18 November 2021

Department of Planning, Industry and Environment
Attn: Bruce Zhang

Request for Advice – Request for Further Information for Oakdale West Estate Stage 3 - SSD-9794683 at 2 Aldington Road Kemps Creek

Figure 4: Proposed Lots 2C and 2D Warehouse Developments

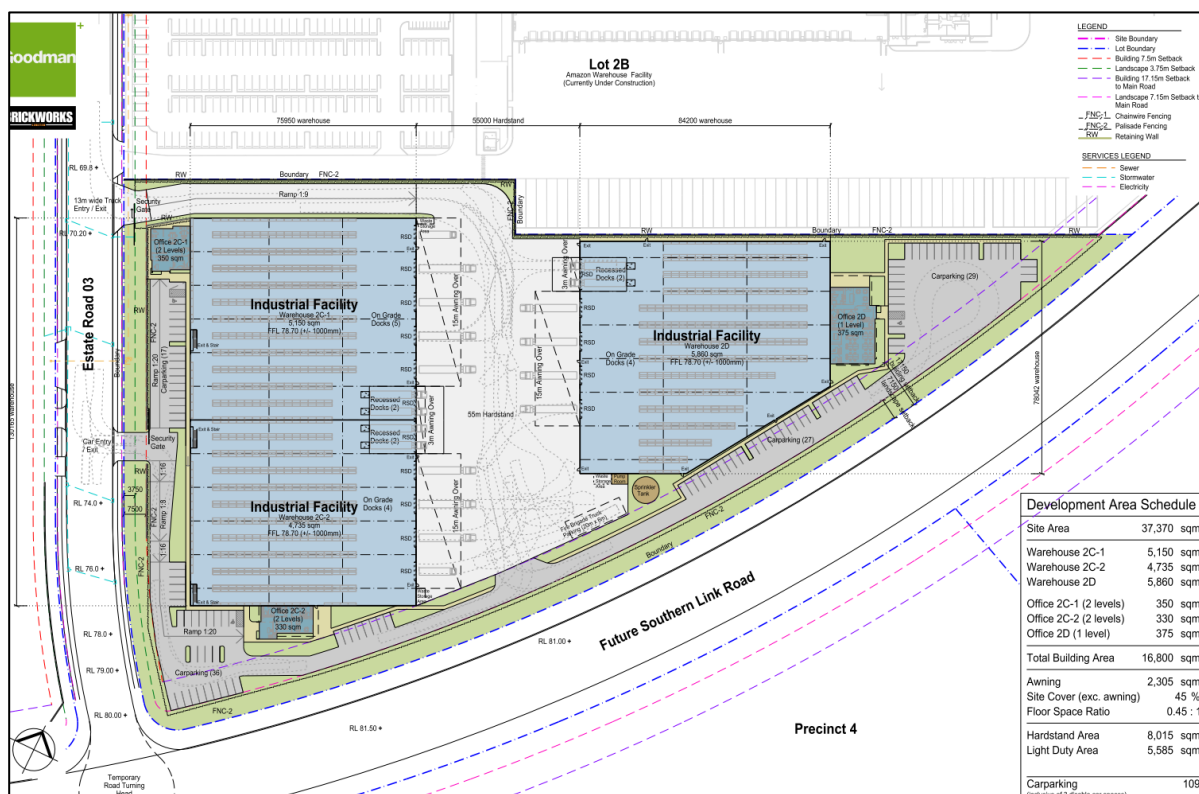
The access driveway for passenger vehicles for Lots 2C & 2D (off Road No 3 – Emporium Avenue) is shown as 9.5m wide. Access driveway widths for passenger vehicles shall be in accordance with AS 2890.1 - Clause 3.2.1, Table 3.1 and Table 3.2. Fully dimensioned plans are to be provided demonstrating compliance.

Turn paths for the left turn movement out of the heavy vehicle access driveway onto Road No 3 (Emporium Avenue) are to be included. Turn paths are to be shown for a 26m B-Double (PBS Level 2 Type B). Road No 3 will ultimately connect to the future Southern Link Road which will become the main access route to the site.

Any driveway, including the wing of the layback, shall be located a minimum of 1m from the lintel of any stormwater kerb inlet pit. The heavy vehicle access driveway for Lots 2C & 2D does not appear to comply with this requirement.
